Application number: 2023/91405	
What is the application for?:	Erection of foodstore (class E) with associated access, parking, servicing area
Address of the site or building:	Part of former St Luke's Hospital site, Blackmoorfoot Road, Crosland Moor, Huddersfield, HD4 5RA
Postcode:

## User comments

Figure 5.2 Proposed Site Plan

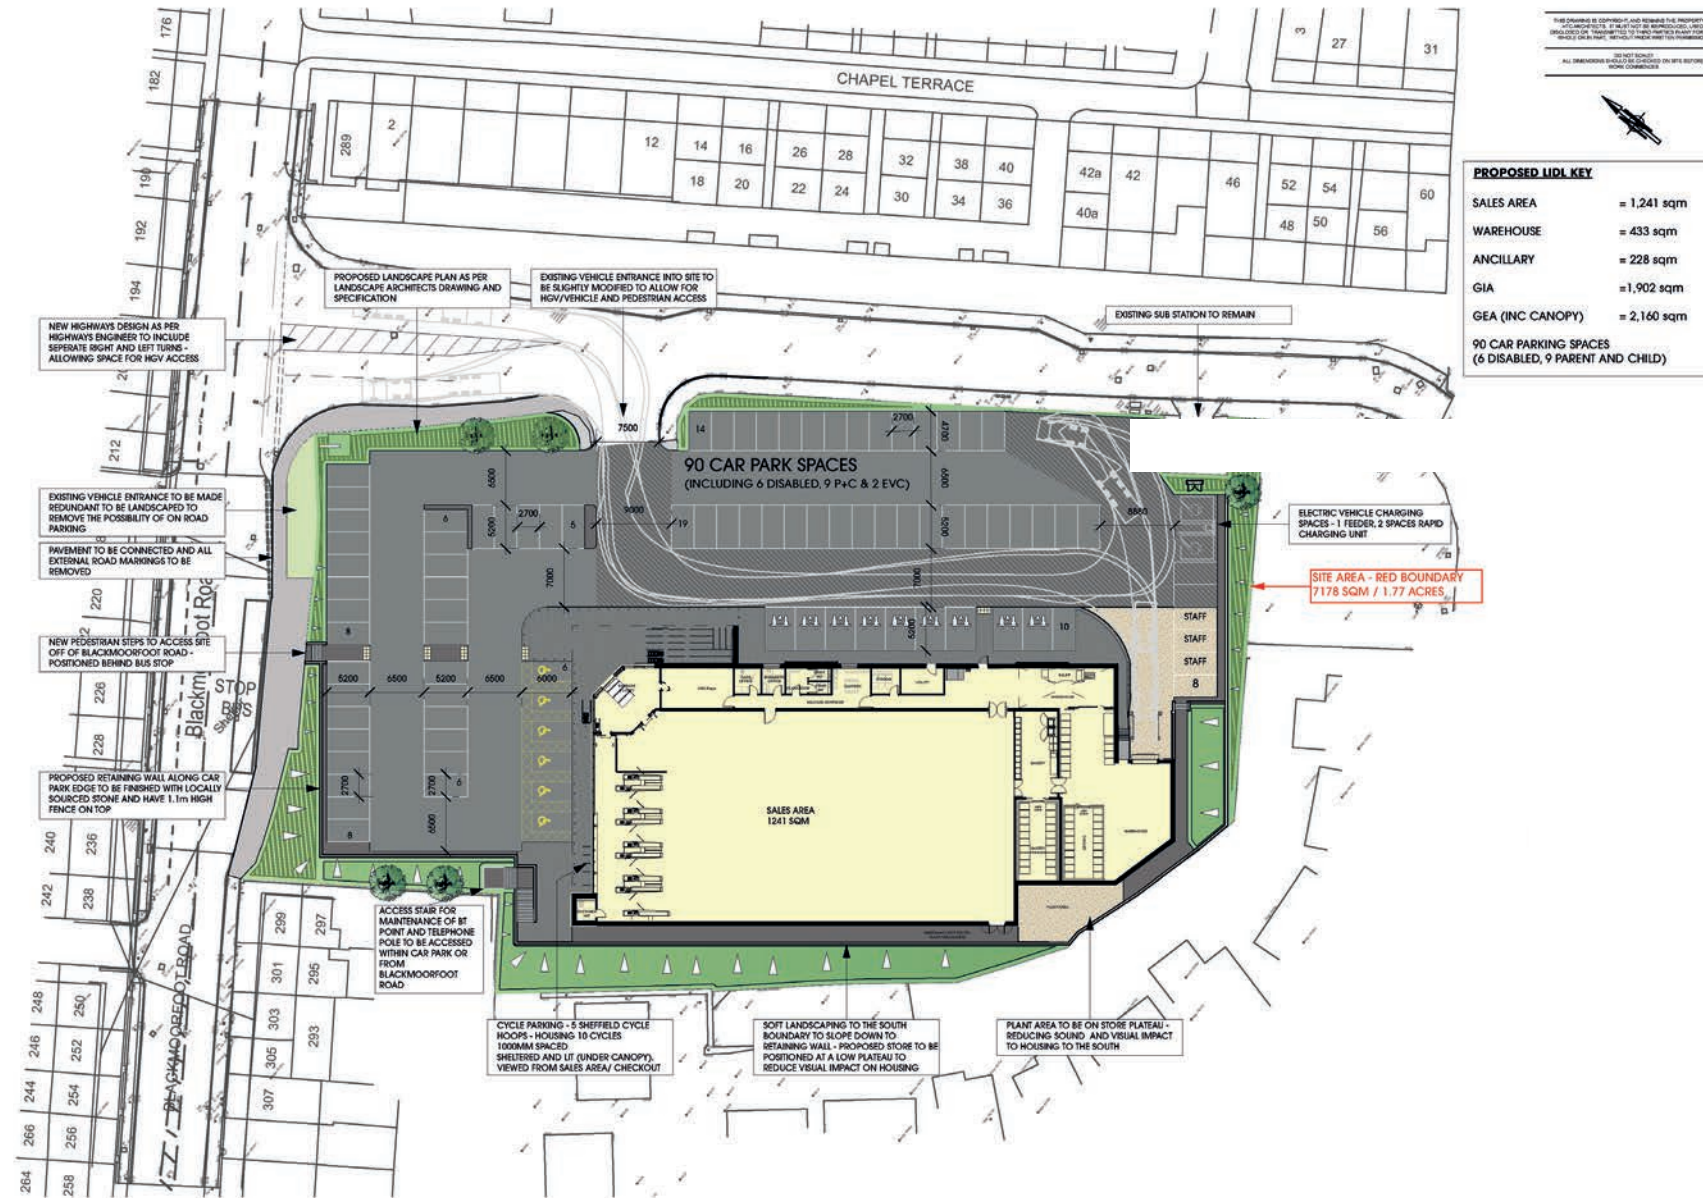
Type of comment: A general comment	
Do you wish your comments to be published on the website anonymously?	<input type="checkbox"/> Yes
Can Lidl please look at the entrance to the store being on Turnstone Way, there will be more traffic on this way or even look and redesign the junction and install a roundabout at that junction of Turnstone Way and Blackmoorfoot Road, which will slow down traffic and speeding coming up and down Blackmoorfoot Road, safety has to be an option at this stretch of road. Please have a look at this.
